Our Ref: JB/942/R1 Wolvercote

Date: 03 December 2020

Former Londis store, 2 St Peters Road Wolvercote Oxford OX2 8AU - Proposed Stopping Up of Public Highway via S247 Town & Country Planning Act

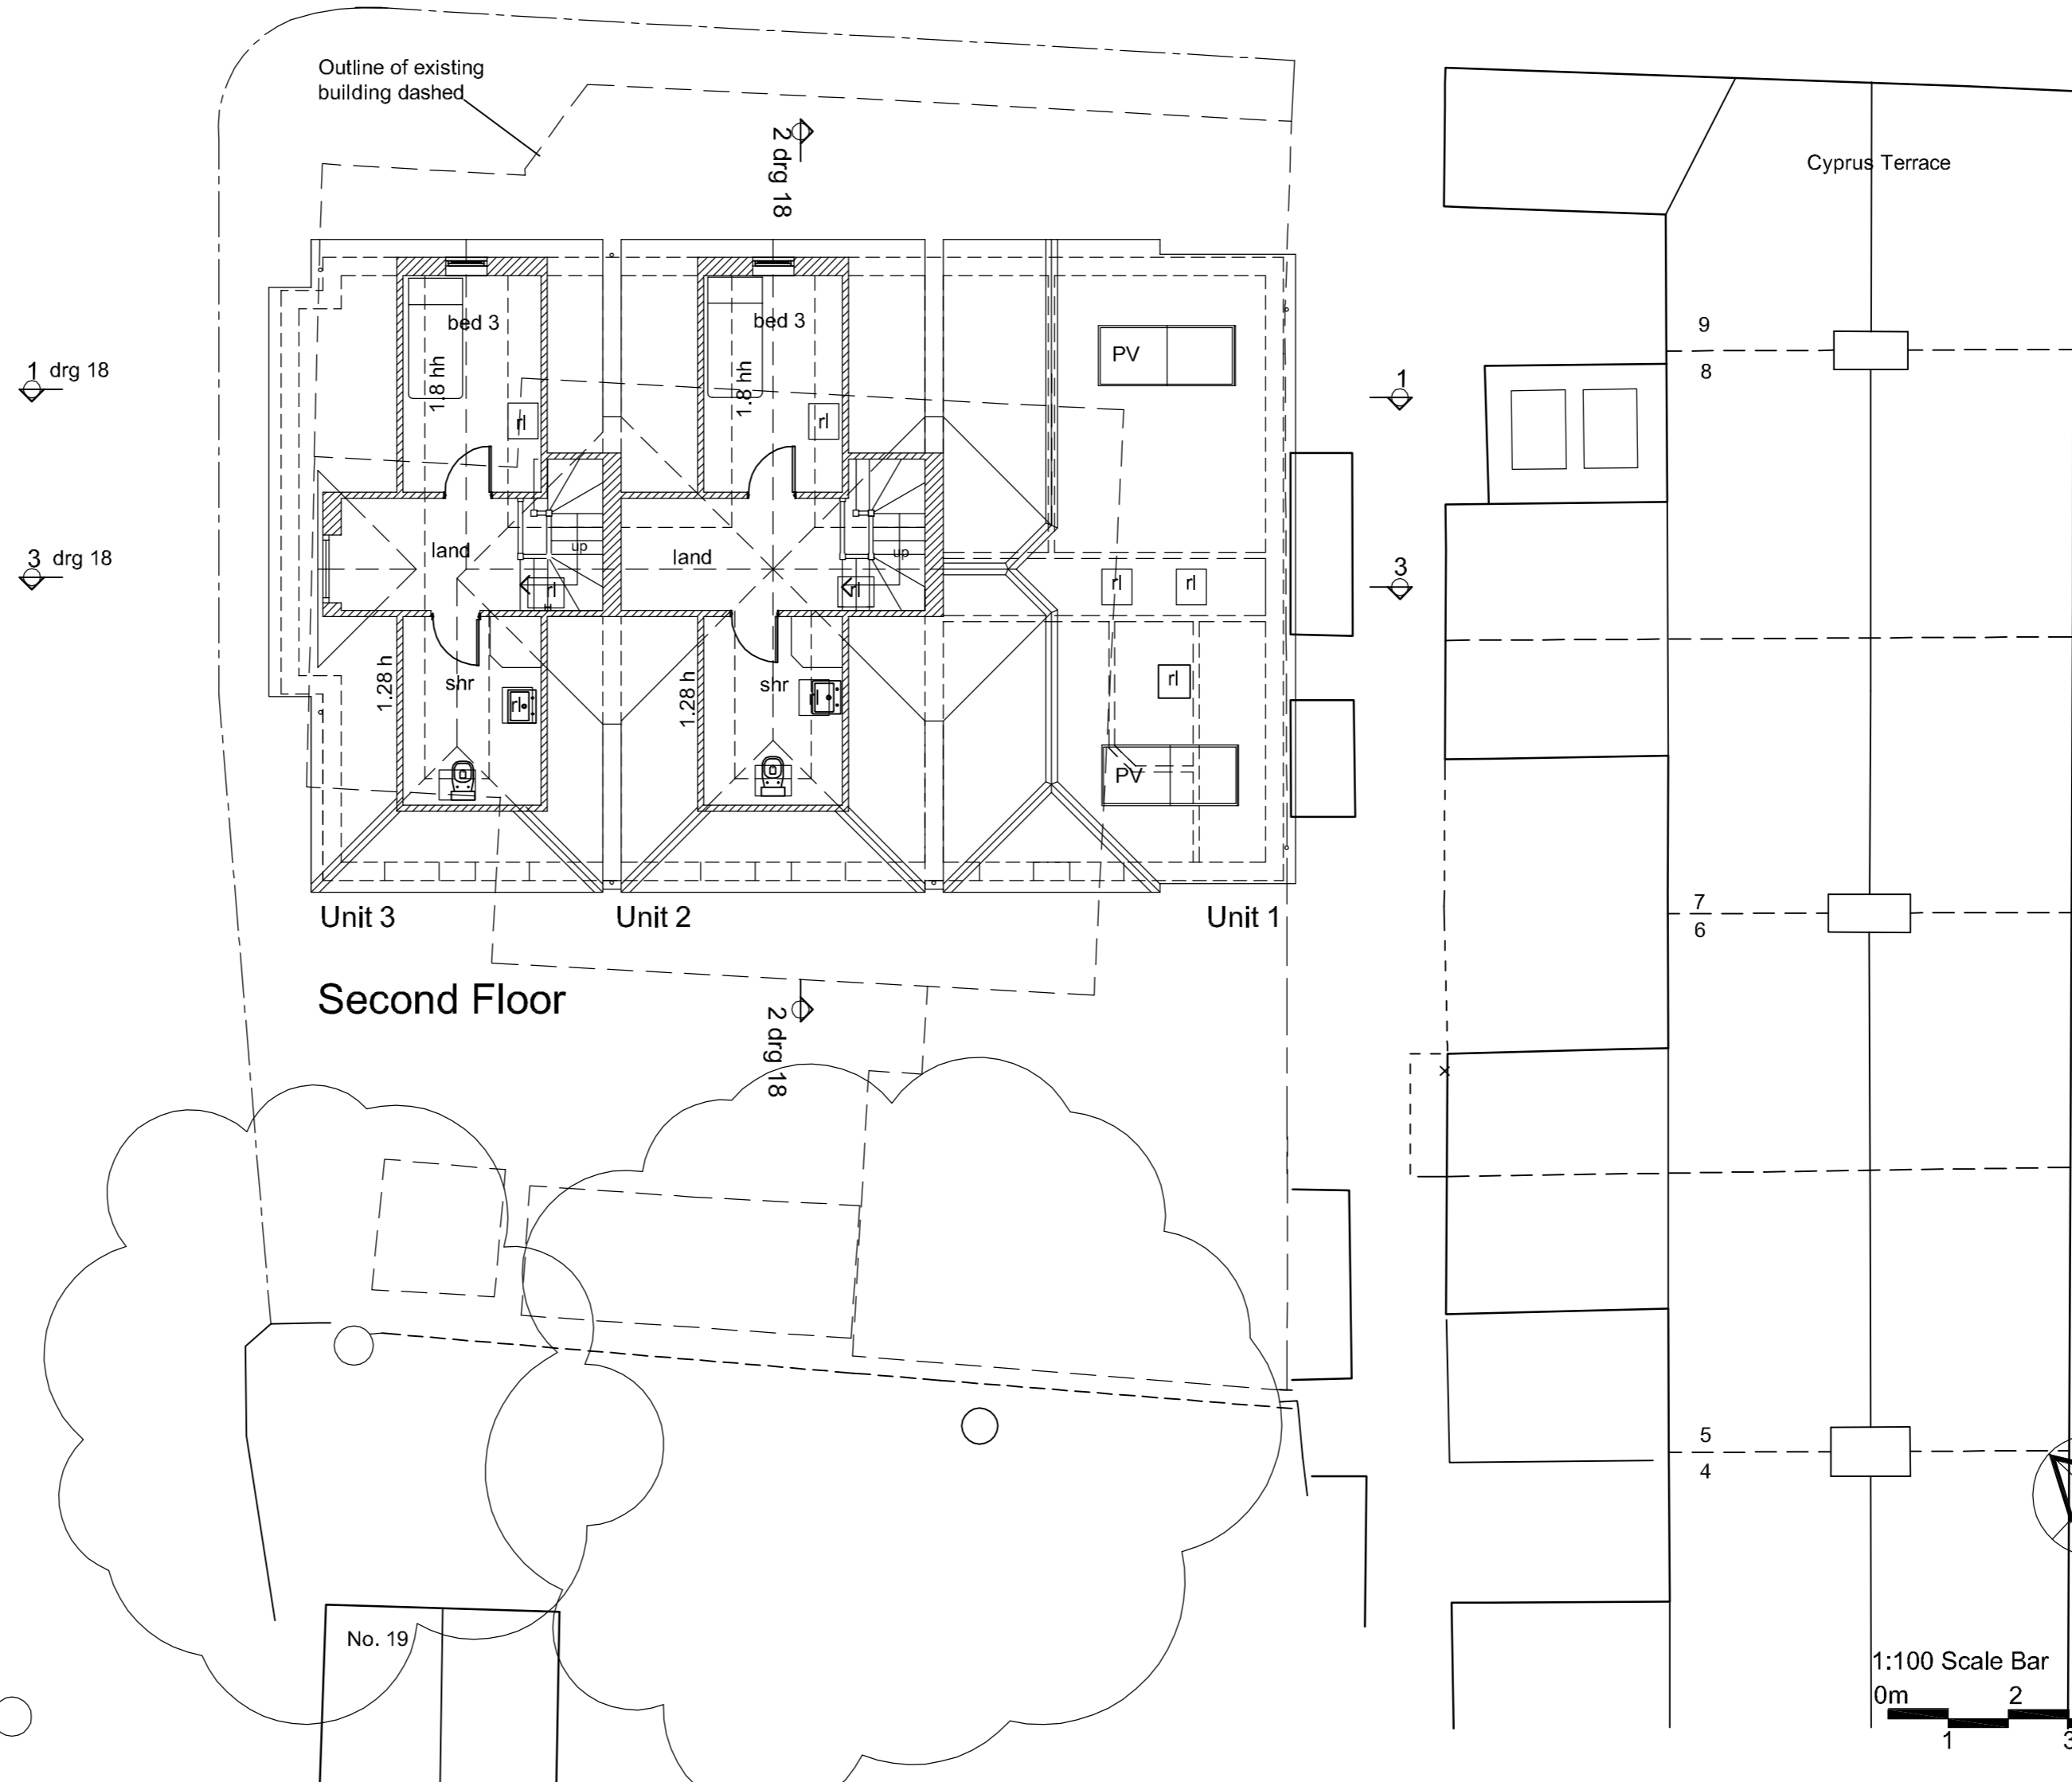
You will note that the approved plan has a reduced proposed stopped up area than the one you requested. This is due to Oxfordshire County Councils concerns over safety and pedestrian amenity.

It has been felt in this case as the existing very narrow footway (0.85m) to the south-west of the site and the significant use of the footway in order to access the neighbouring school at the start and end of the school day as well as the absence of a footway on the north side of the road, we must aim to provide a good rather than bare minimum standard of footway to provide an appropriate and effective walking route as possible. In this case a 2.5m width footway must be retained whilst taking into account the current highway boundary to maintain an acceptable vision splay from St Peters Road.

Another point that has been raised, there appears to be existing cable TV / broadband service which seems to conflict with the proposed area to be stopped up. You will need to consult all the Public Utility Companies in your area (if you have not already done so) by sending them a copy of your plan and asking them:
